Martin Nugent
01254 828060
D3/12/0655

Drafted 5 October 2012

**Planning Application, Ribble Valley District
D3-12-0655 Townson Bros, Pendle Trading Estate, Chatburn**

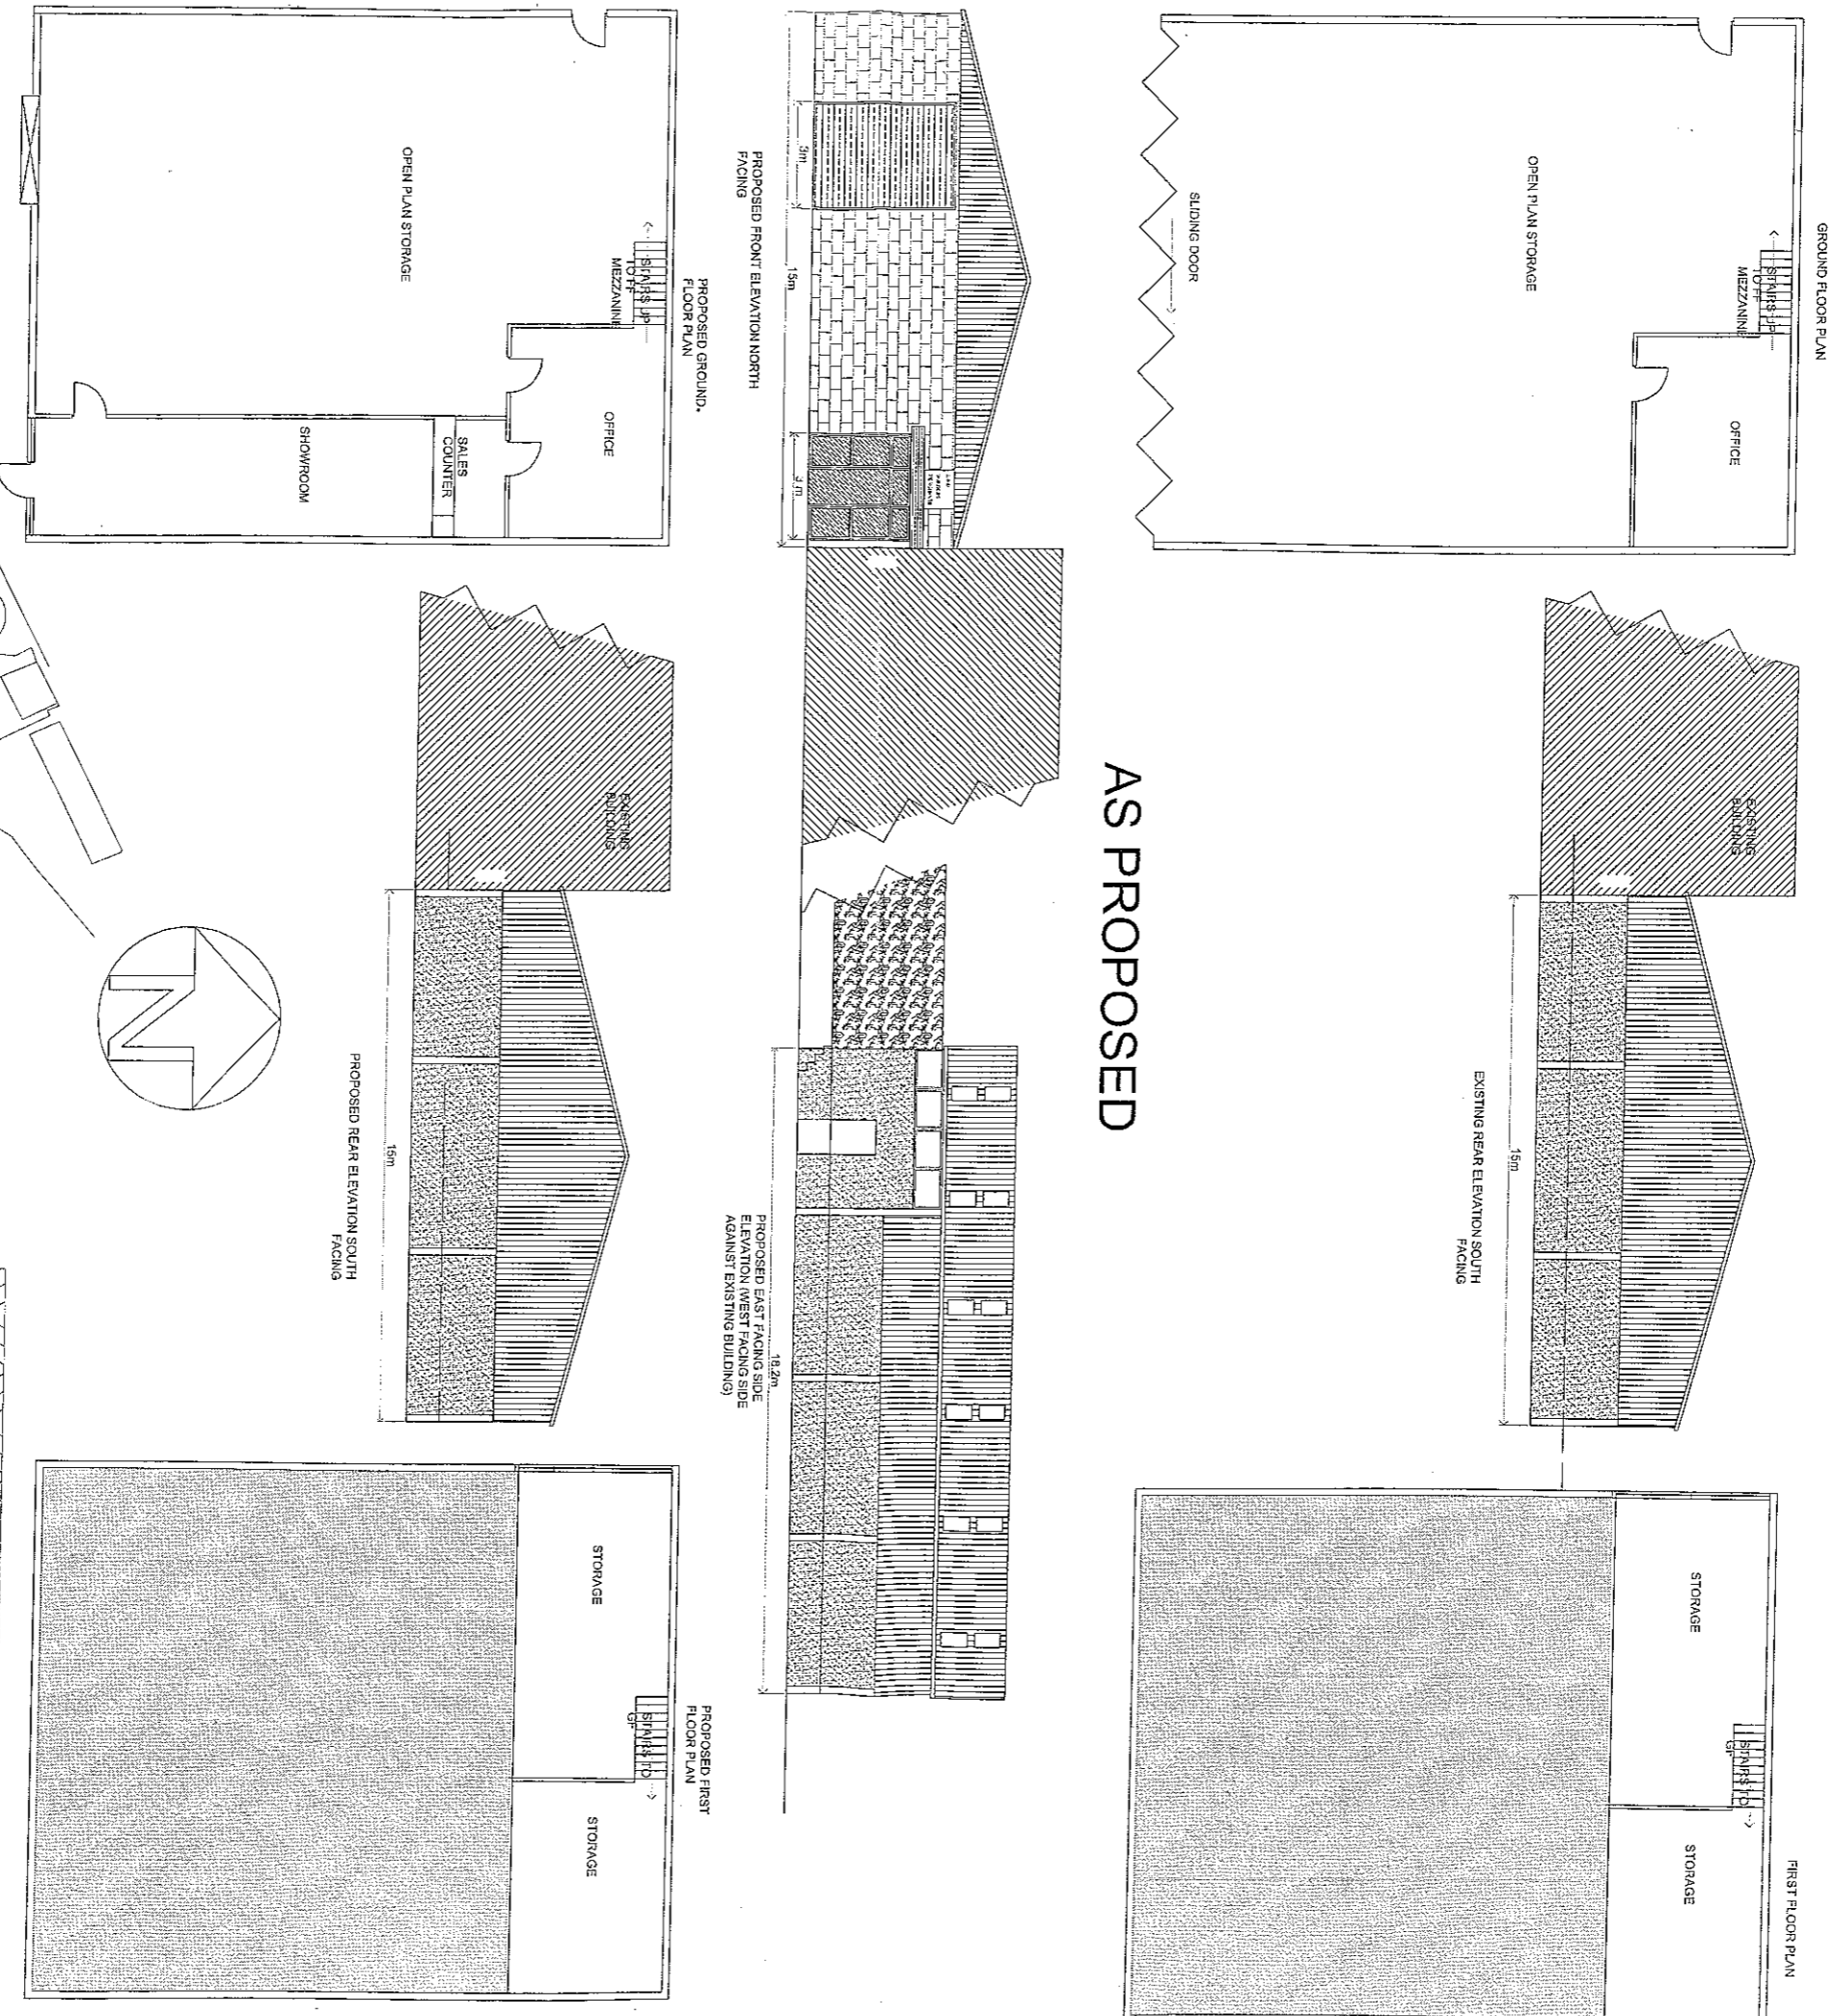
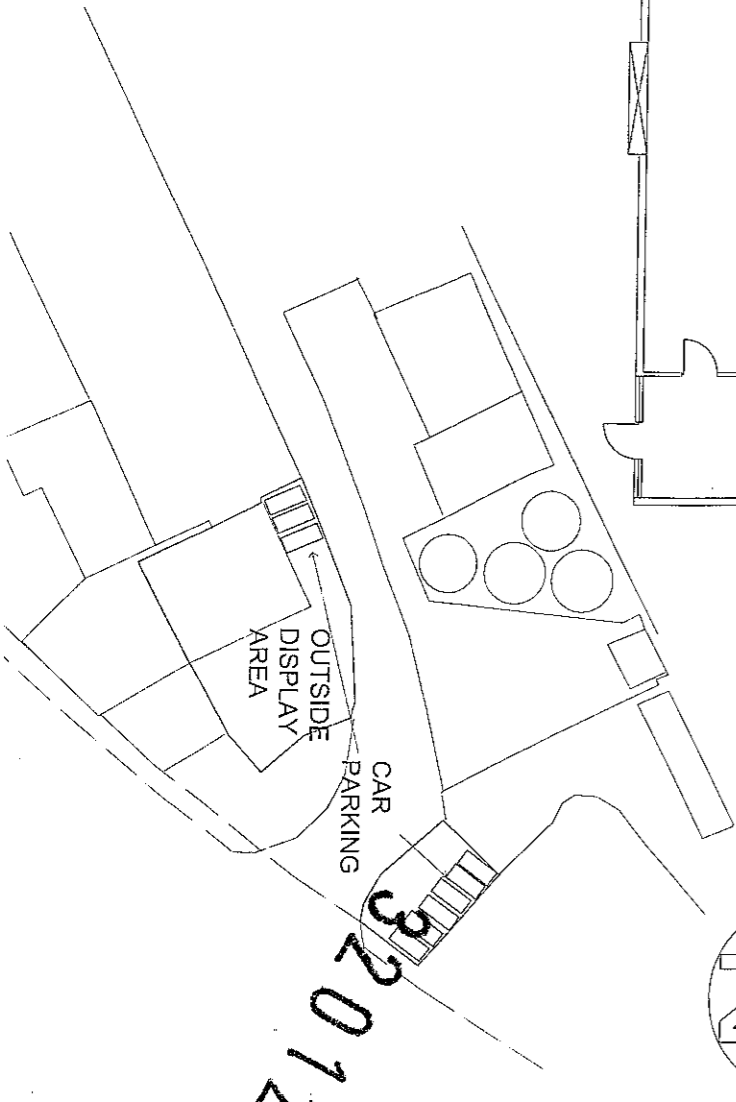
The operation of the main building within the proposed development does not present any inherent highway safety issues. The separation of the retail unit from the designated car parking is not ideal as it will require customers to take goods across the service road. However, the parking is positioned in a conspicuous location close to the main building and offers convenient access to the development.
